DEVELOPMENT REVIEW BOARD  
SUPPLEMENTAL SUBMITTAL

Re: Inspiration Subdivision (Project # PR-2018-001759, Application # SD-2018-00129, VA-2018-00234, VA-2019-00025, VA-2019-00026, VA-2016-00027) Comment Response Letter

Enclosed are the responses to the comments provided on April 24<sup>th</sup> hearing. Comments and responses are listed below by department.

PRELIMINARY PLAT INSPIRATION (REPLAT OF TRACT A & B INSPIRATION SUBDIVISION) ALBUQUERQUE, NEW MEXICO

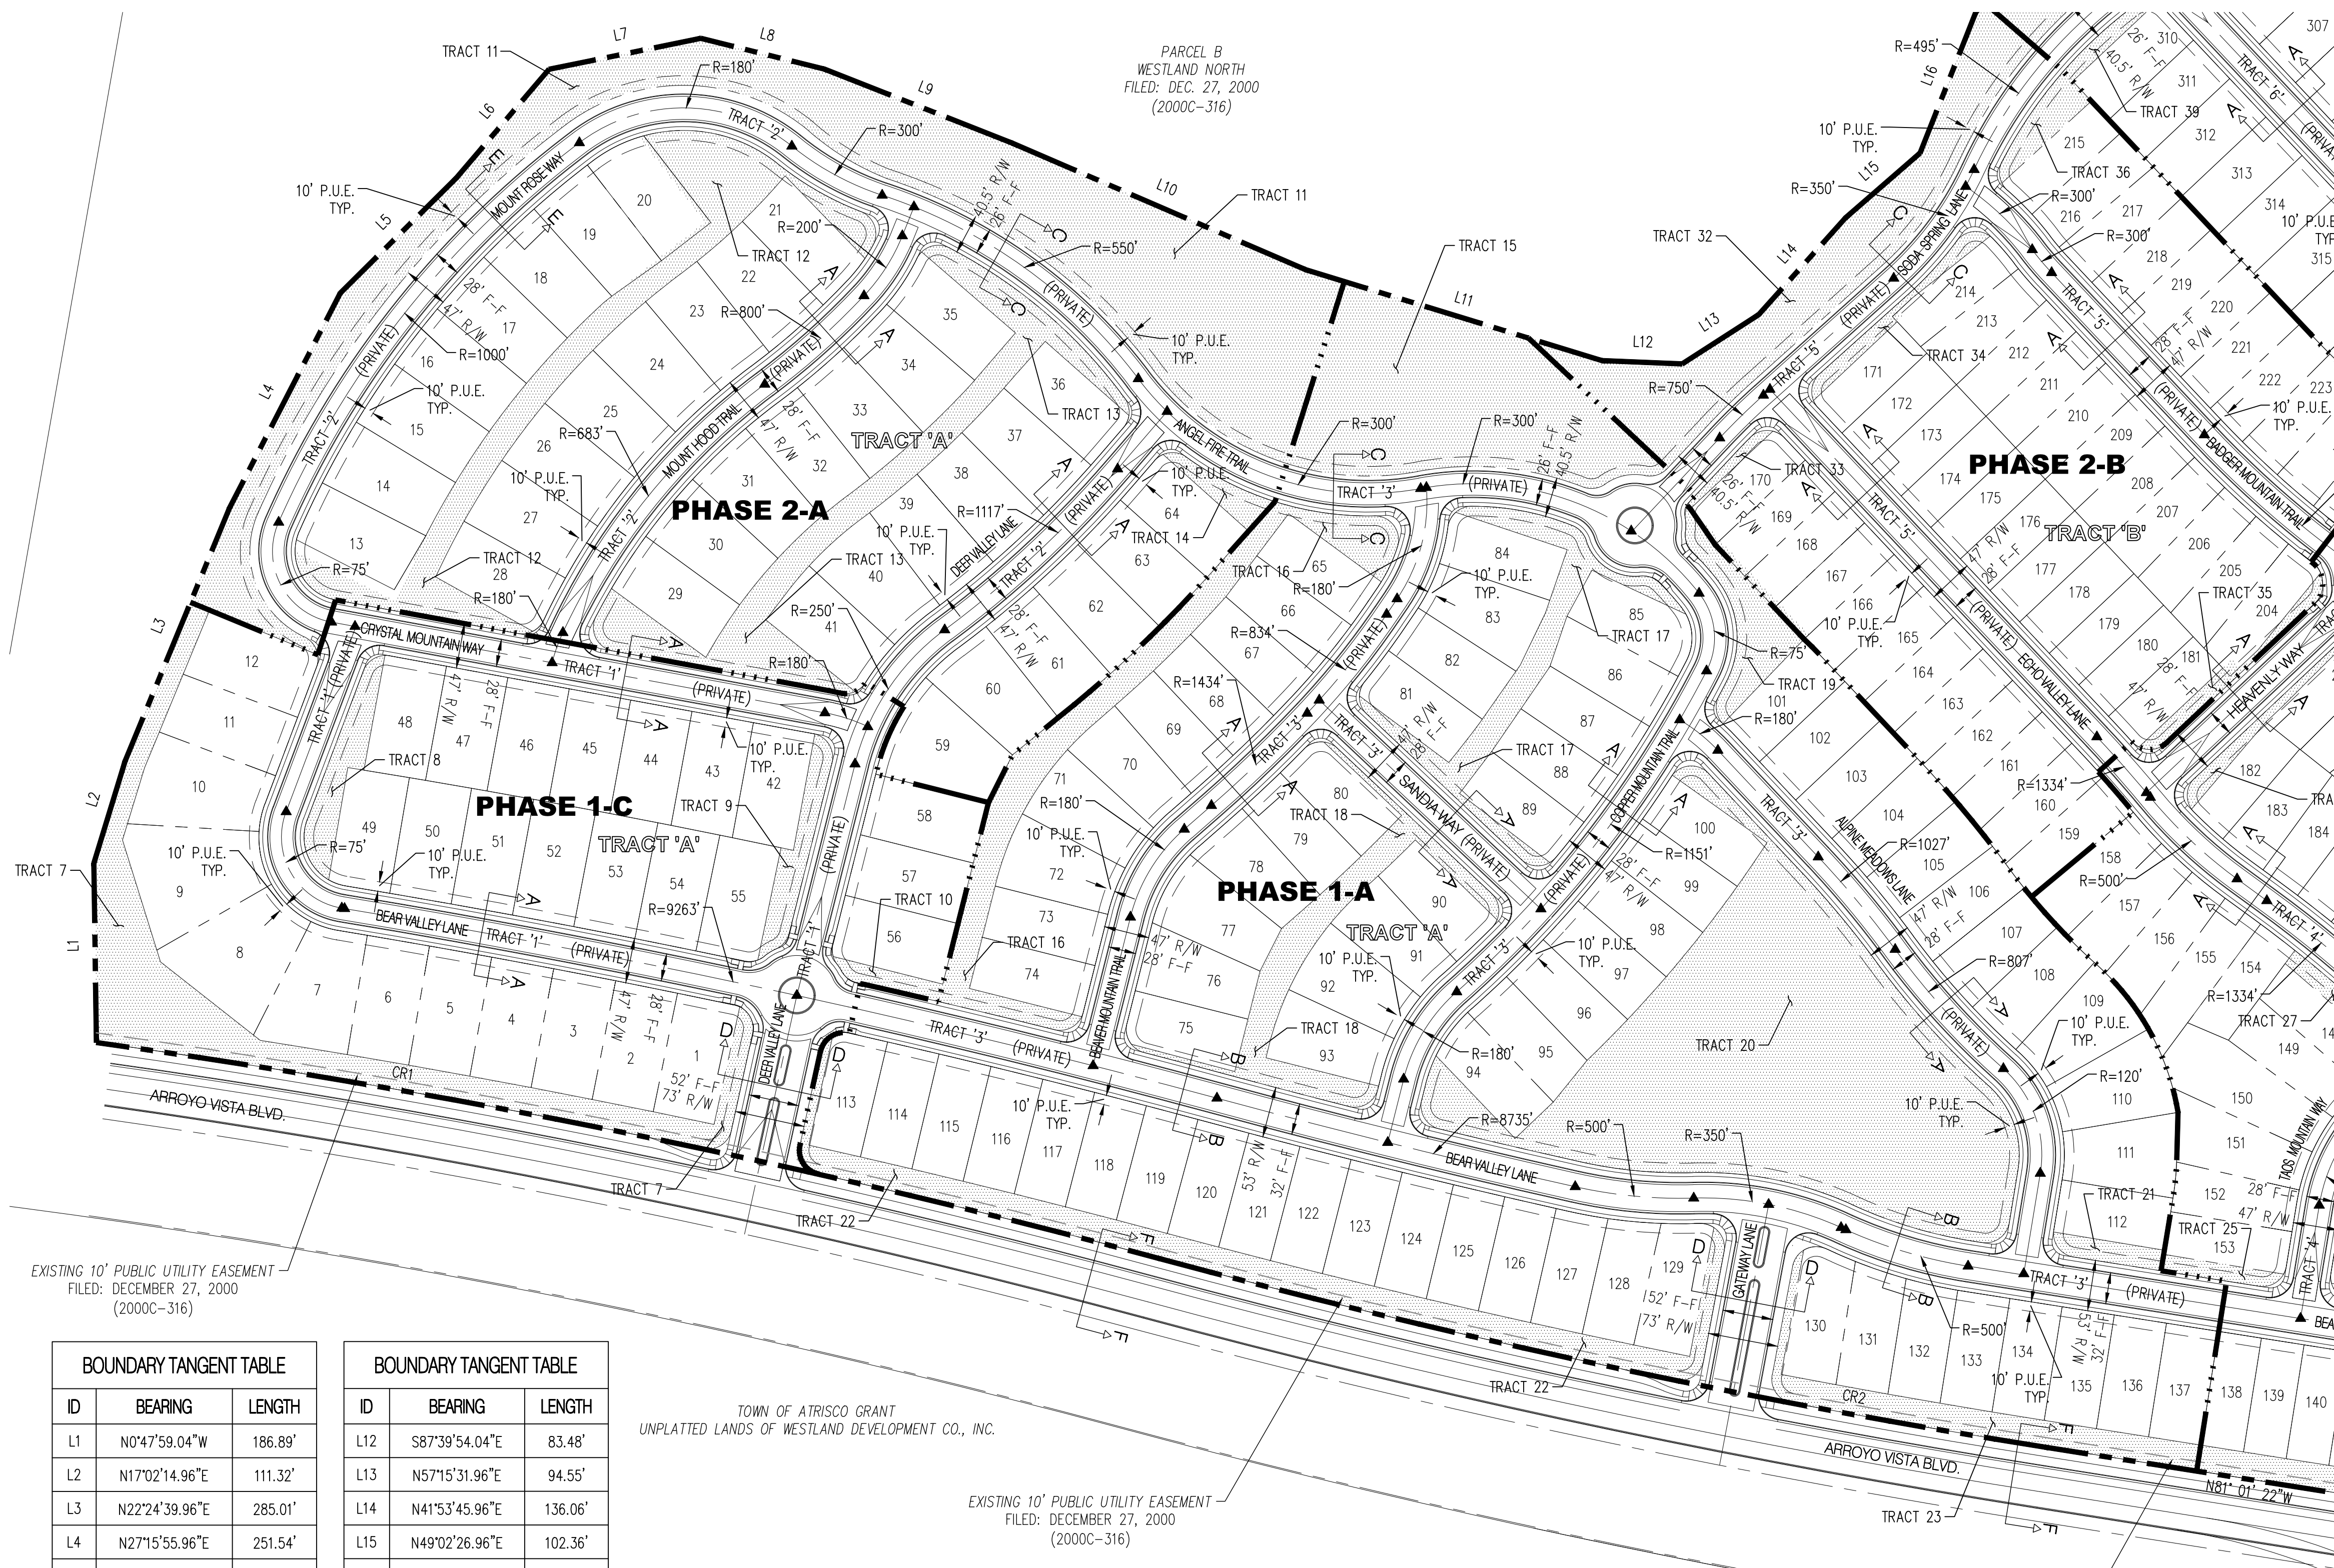
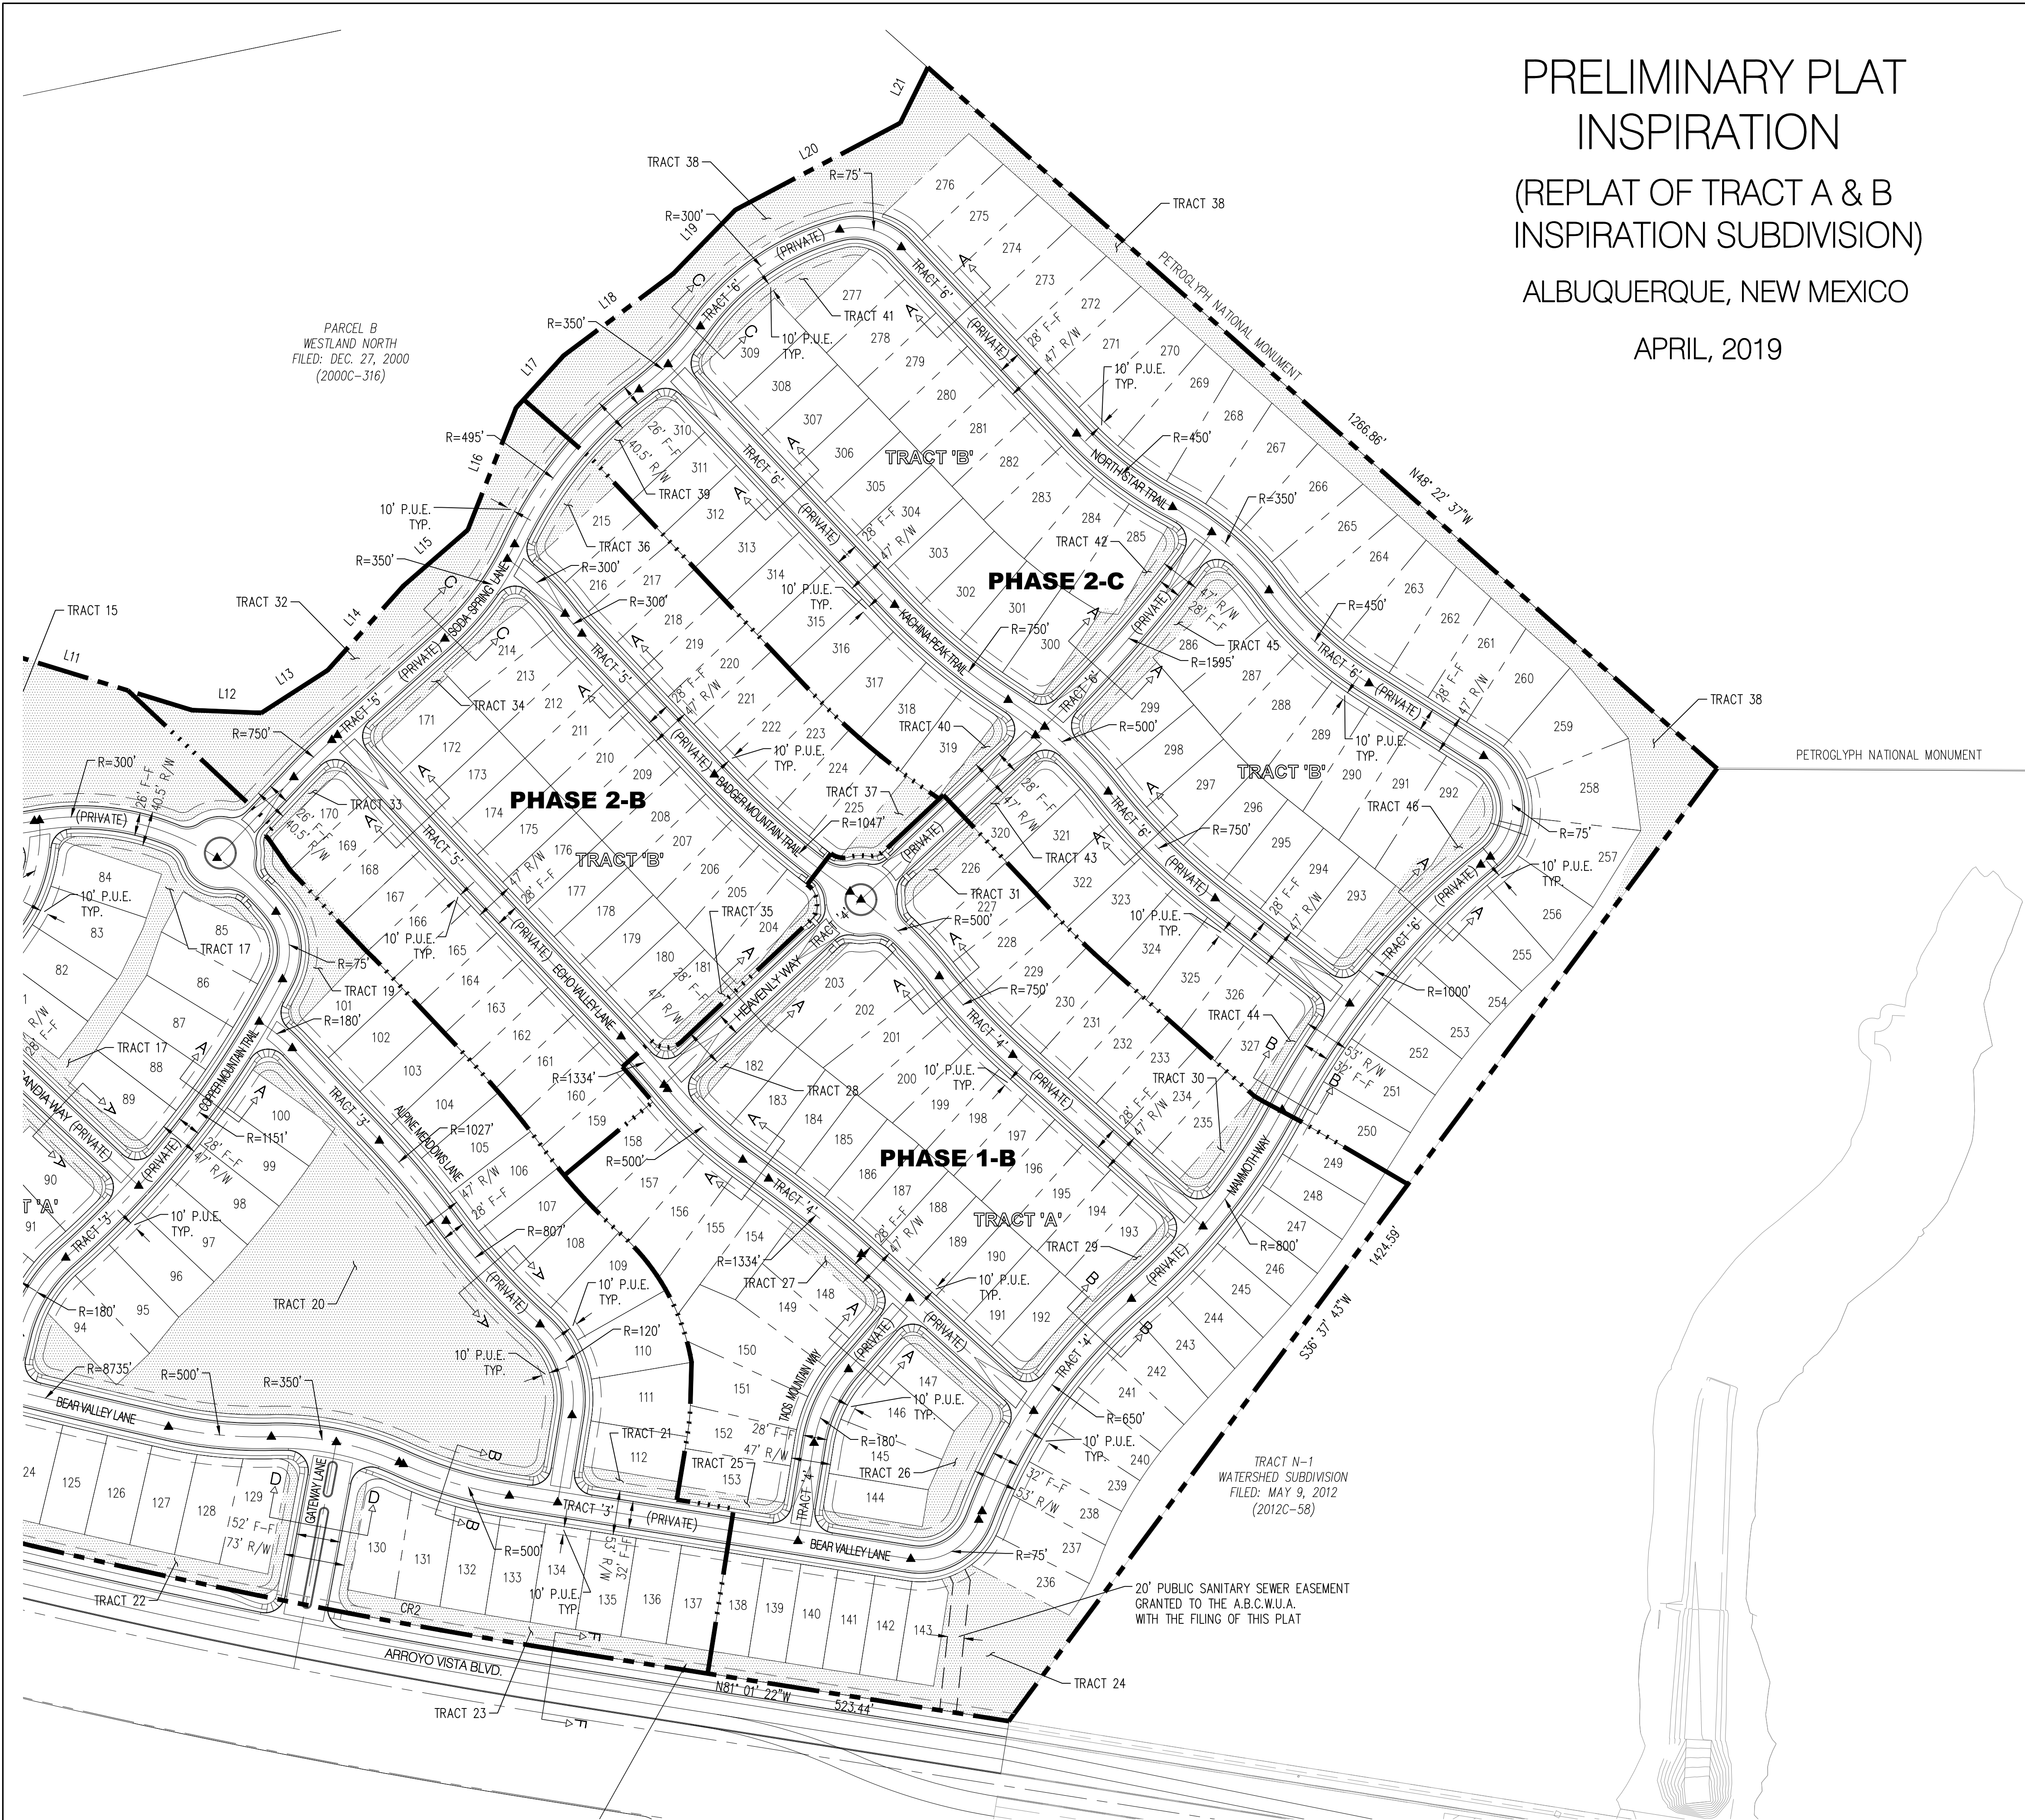
4. Remove the words "for Subdivision" in the notes concerning the site plan. It is an EPC site plan (there is no longer a difference in site plan types ie subdivision or building permit). Add the EPC application number.  
*Response: This has been corrected*

5. Note 4 the wording "granted" must be changed to "to be granted" by plat.  
*Response: This has been corrected*

6. Remove reference of the Sub Ordinance in note 6. Cite the actual wording.  
*Response: This has been corrected.*

3. Provide cross lot drainage easements on the HOA tracts naming maintenance responsibilities (HOA) and Beneficiaries (Parcel B, Westland North and Parcel A, Petroglyph)  
*Response: Cross-lot drainage easements added to the western boundary HOA tracts only which will accept from from Parcel B. We are not accepting any drainage from Parcel A the Petroglyph National Monument since this drainage away from our site. The note is correct on the plat*

4. "See Sheet 3 of 3 for 'drainage facilities maintenance note' for ownership and maintenance responsibility." This sentence needs to be added to the end of Easement Note 9 and 10. For Easement Note 10, delete everything after "H.O.A." and replace with the above sentence.  
*Response: Easement notes have been updated*
